From: Paul Cann <Paul.Cann@arun.gov.uk>
Sent: 14 February 2023 16:45
To: Planning.Responses <Planning.Responses@arun.gov.uk>
Cc: Karl McLaughlin <Karl.McLaughlin@arun.gov.uk>
Subject: RE: Planning Re-Consultation on: Y/55/22/DOC

Application No: Y/55/22/DOC
Registered: 6th May 2022
Site Address: 10 Acre Field Grevatts Lane West Yapton
Grid Reference: 498000 101780
Category: Discharge of Condi
Description of Works: Approval of details reserved by condition imposed under Y/103/18/PL relating to conditions 8-surface water drainage, 9-discharge flows to watercourses and 10-maintenance and management of surface water drainage.

PURECON_DOC (055) 2620

Project No.	Originator	Volume	Lvl/Loc	Type	Role	Number	Rev
13591	CRH	XX	XX	DR	C	5051	P7

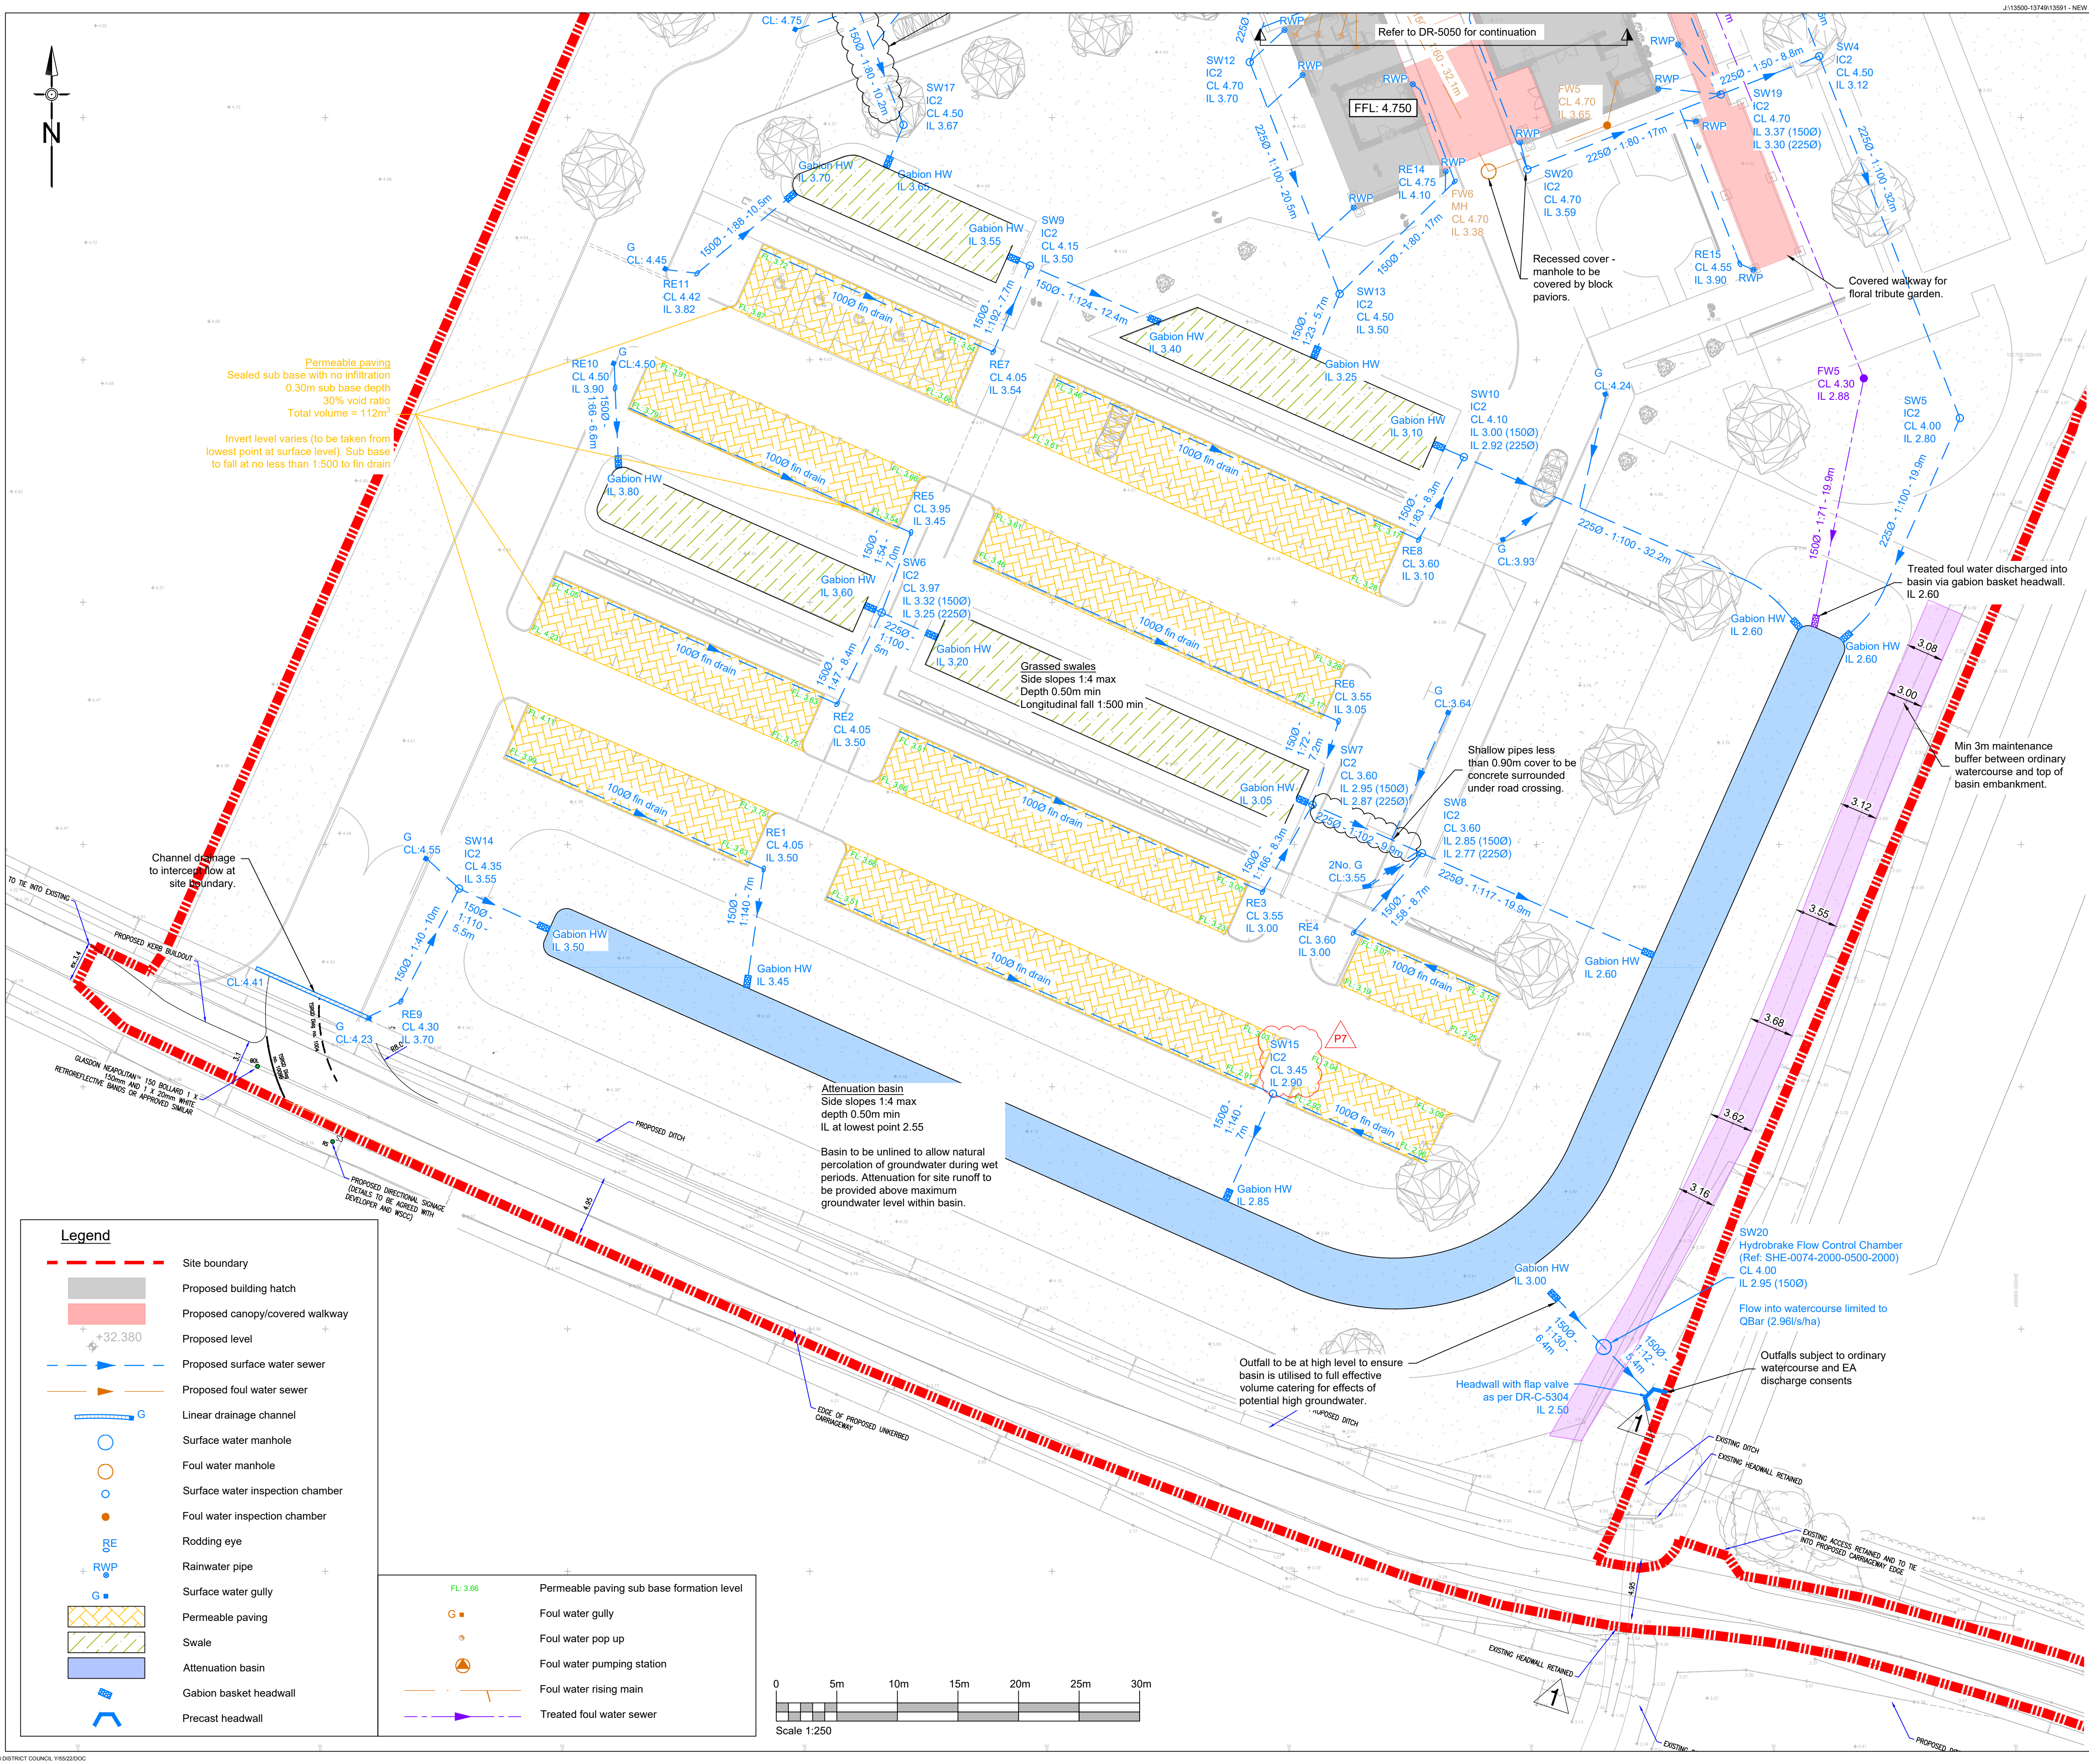
- Whilst the applicant's response states that the "attenuation basin and swales are to be unlined, while all permeable paving is proposed to be lined with permeable membranes", drawing CRH-XX-XX-DR-C-5051-P7_Proposed Drainage Layout (Sheet 2) has a label which states "Sealed sub base with no infiltration". This drawing is required to be updated.

Label still states, 'subbase with no infiltration'. Please update the drawing.
